From: Anita Gardner
Sent: 01 June 2017 16:09
To: Karen Parsons
Subject: FW: A/64/17/DOC 1-6 The Cottrells, Angmering

In addition I have subsequently received the comments of the Conservation officer who has stated that some of the materials specified on the 'External Materials List' submitted to discharge the condition (A/64/17/DOC) are consistent with those approved under A/105/16/PL. However, there are a number of deviations:

Rev	Description	Date
Job Reference New House The Cottrells Angmering Client AM Homes Ltd		
Drawing Title Site Works Plan Drawing No AD962/03 Rev		
Date	Scale	Dwg Size
28.02.17	1:100	A3
	Plot Style	Drawn
	ADCgreycols	TDG
	Checked	AD

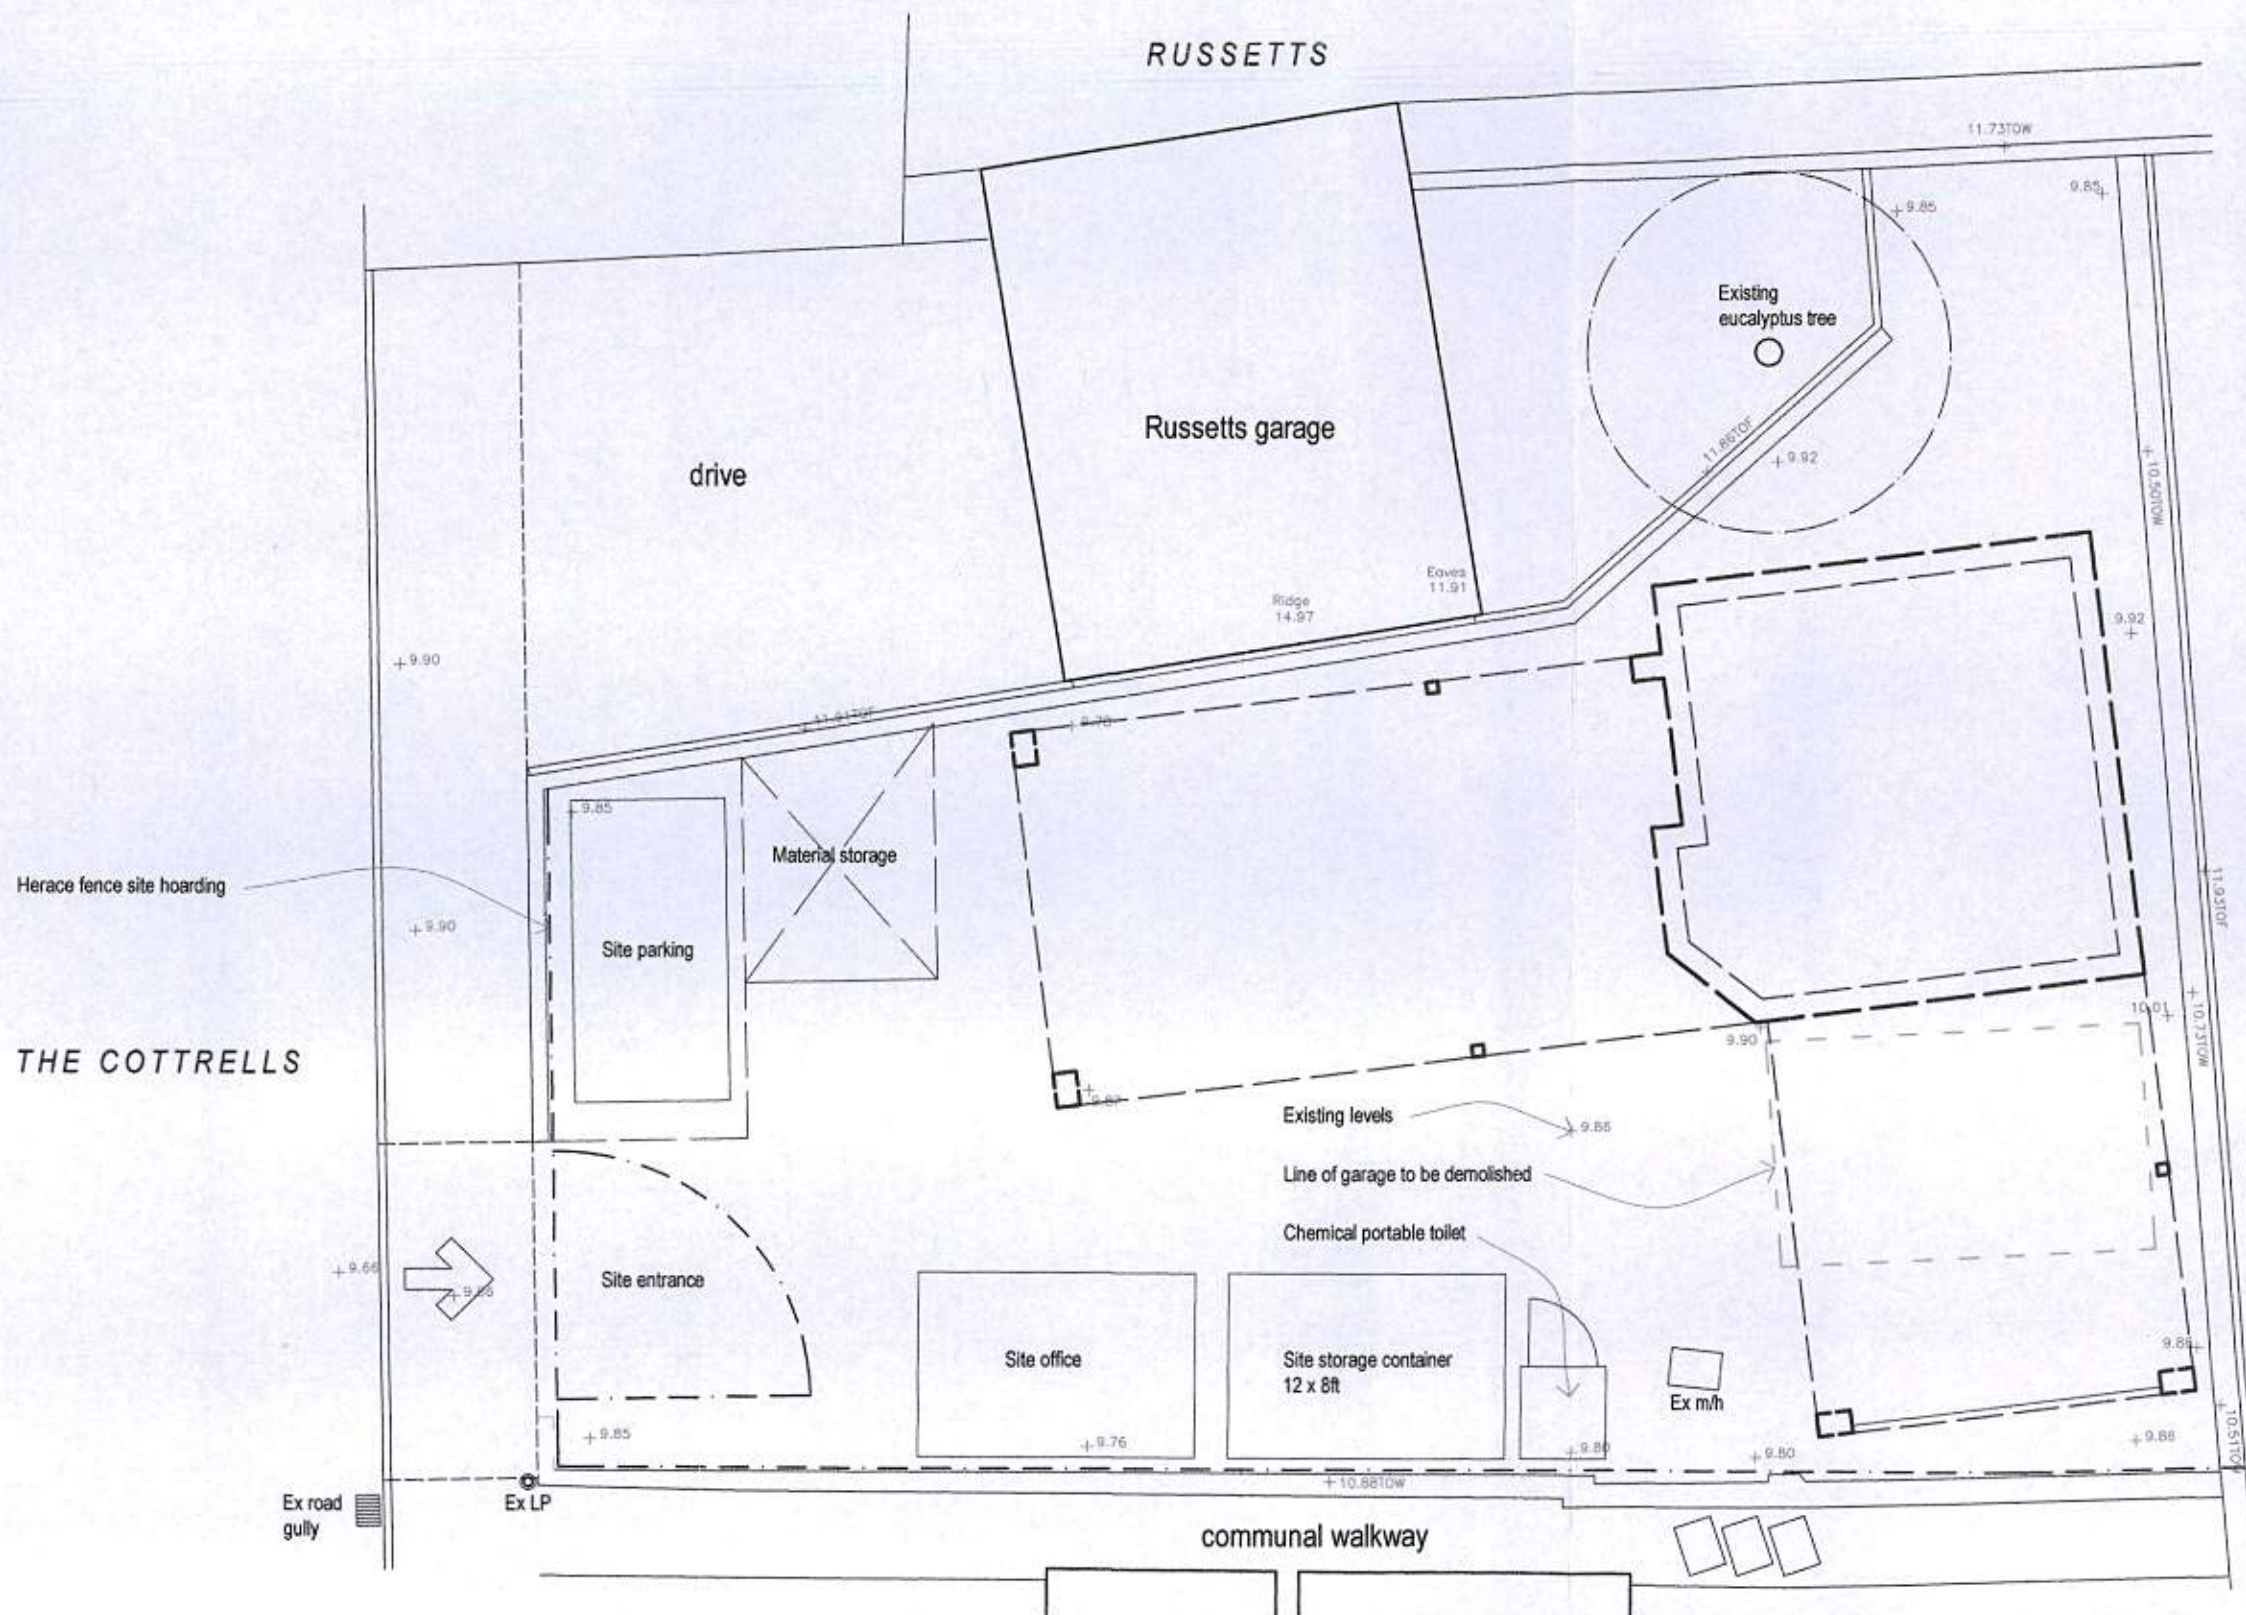
I have received the attached consultation response from County Highways and would appreciate receipt of the additional information requested within the next 10 days or it is likely that discharge of condition 5 will be refused.

Thank you for the email and please find attached our amended drawing No ADC 962/03A.

In response to the Highways query I confirm materials can only be delivery by small or medium sized vehicles due to the narrow site entrance into the Cottrells. As such we are able to accommodate such vehicles within the site area without blocking the cul-de-sac of the Cottrells.

A		Flatbed delivery lorry added		04.05.17	
Rev		Description		Date	
Job Reference			Client		
New House The Cottrells Angmering			AM Homes Ltd		
Drawing Title			Drawing No		
Site Works Plan			AD962/03		
			Rev		
			A		
Date	Scale	Dwg Size	Plot Style	Drawn	Checked
28.02.17	1:100	A3	AD09xscale	TCG	AD

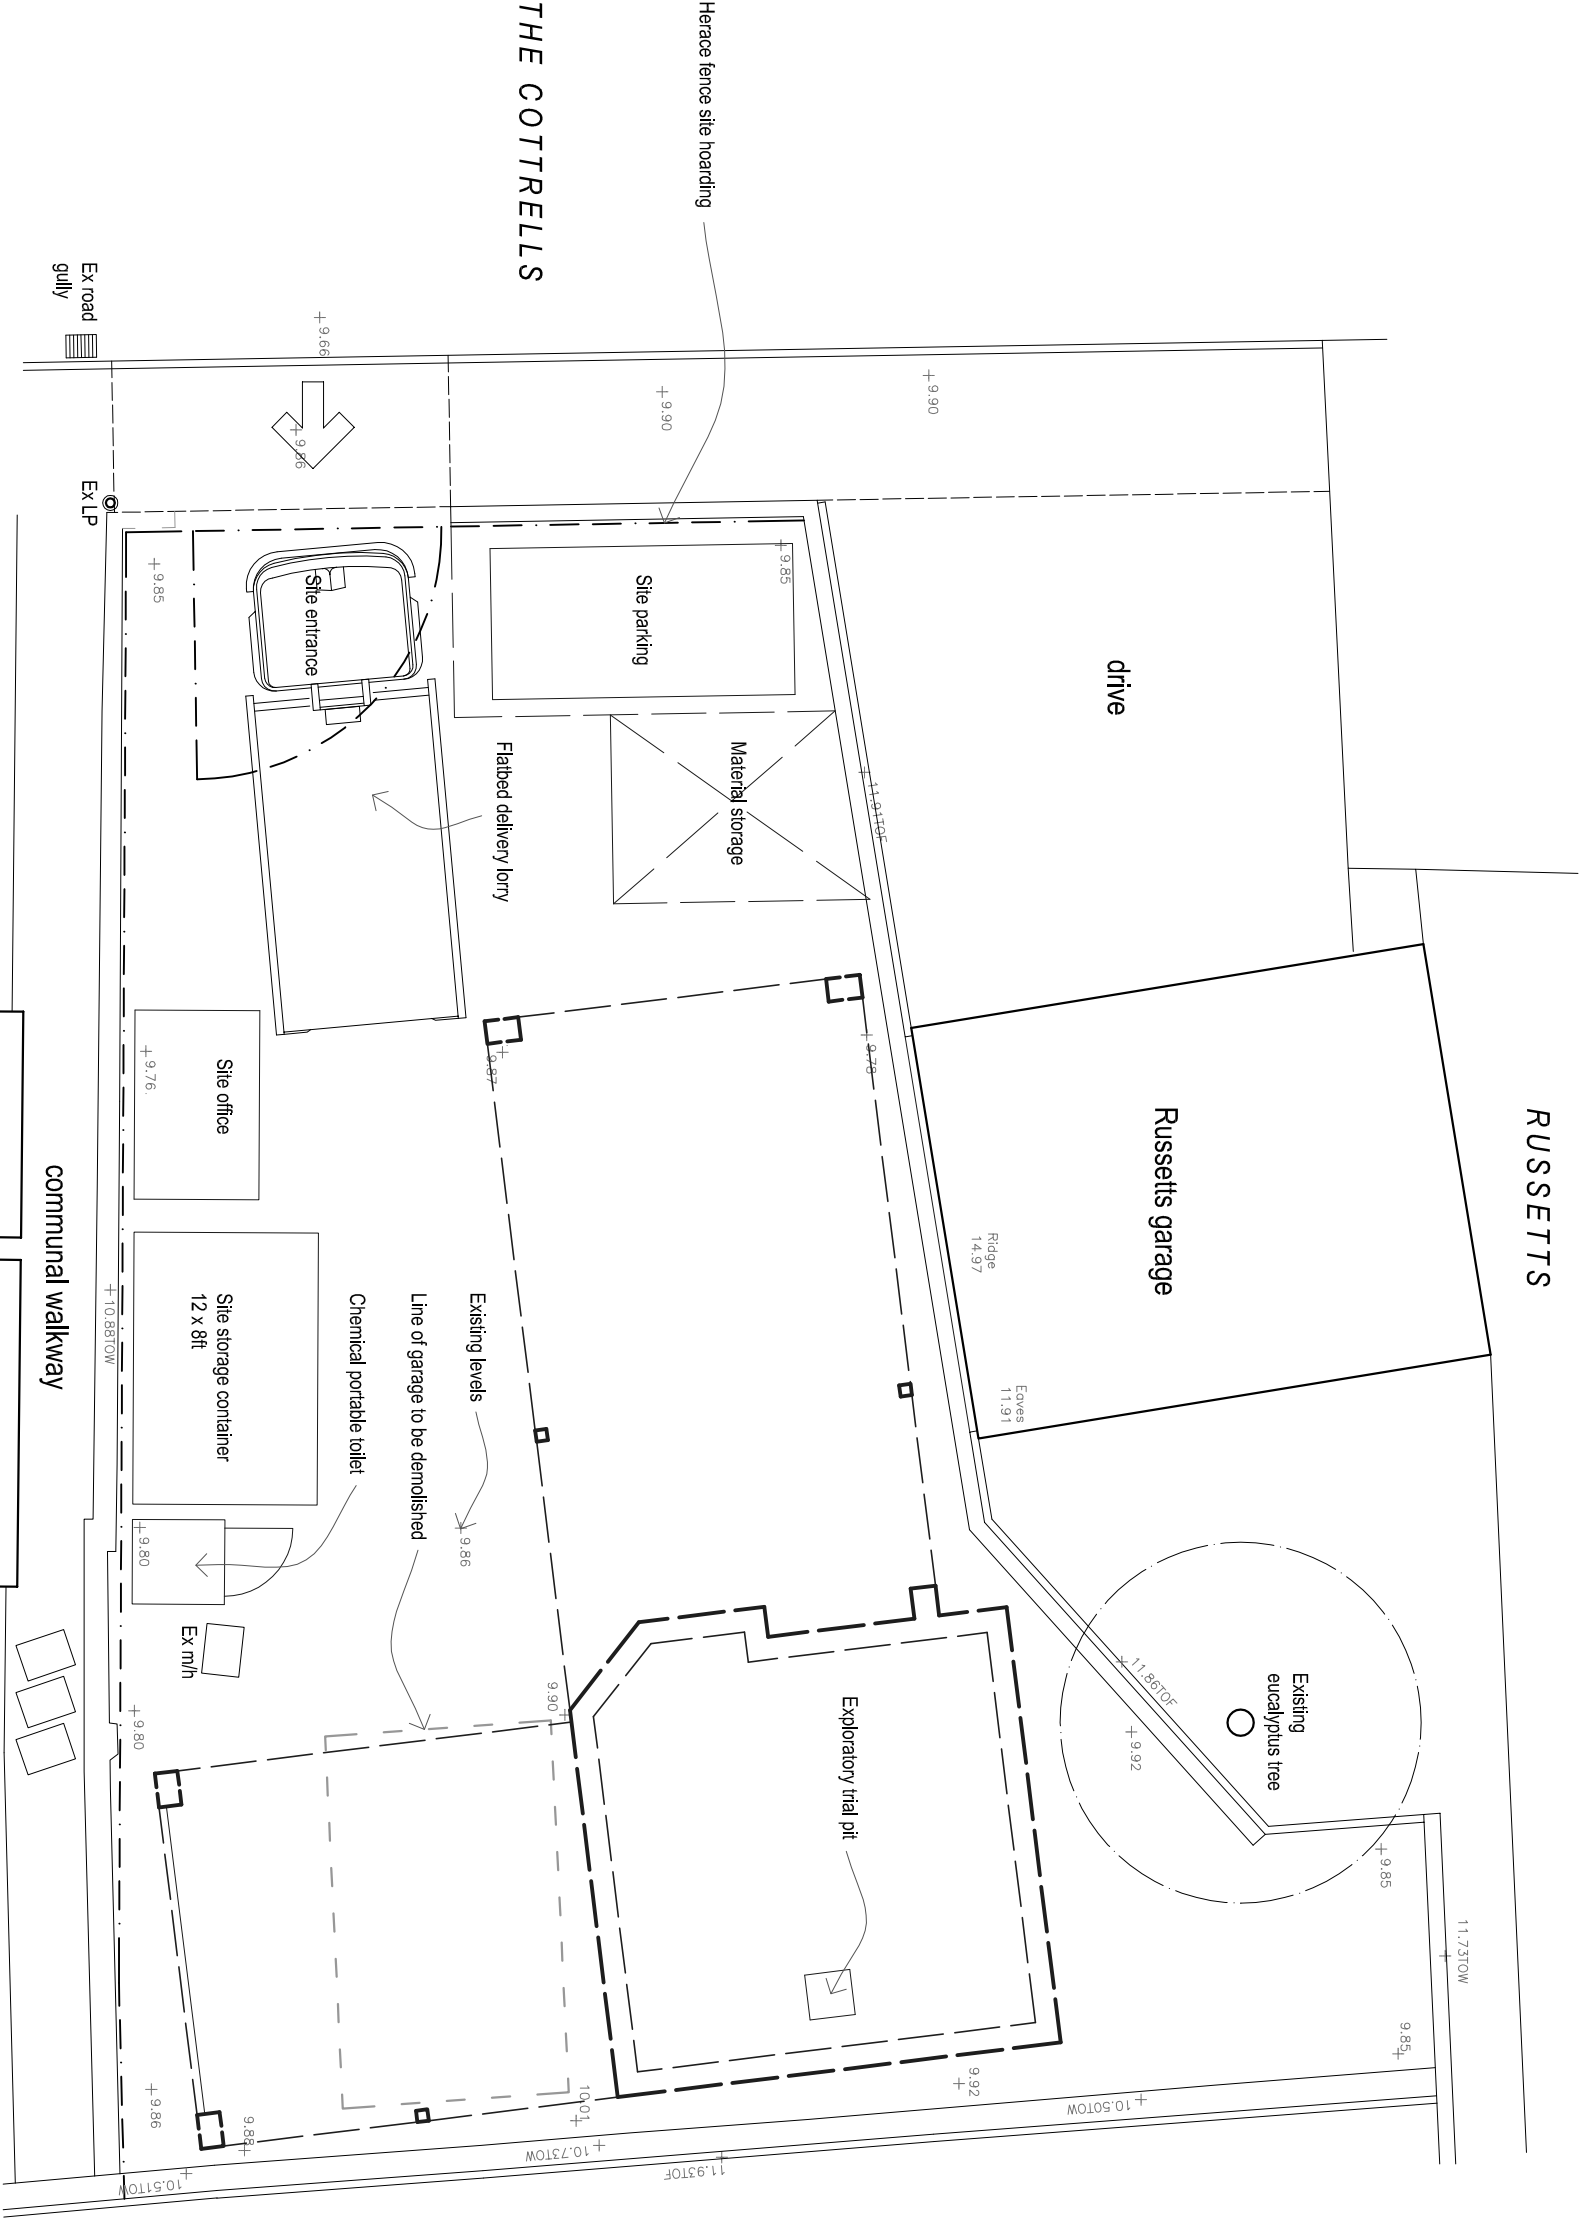
Thanks for this, based on the revised plan (AD962/03 A) the applicant has demonstrated how a flatbed delivery lorry could be facilitate on site. It is clear from this plan that such a delivery lorry would not be able to turn on site. I would therefore recommend an annotation on the plan detailing that any reversing movements into or out of the site by construction vehicles are undertaken with the use of a competent banksman.

It is appreciated that some deliveries may need to be undertaken from the roadside.

Subject to the above amendment I would be minded to accept that that plans and details provided pertaining to condition 5 of A/173/16/PL are now acceptable from a highways perspective.
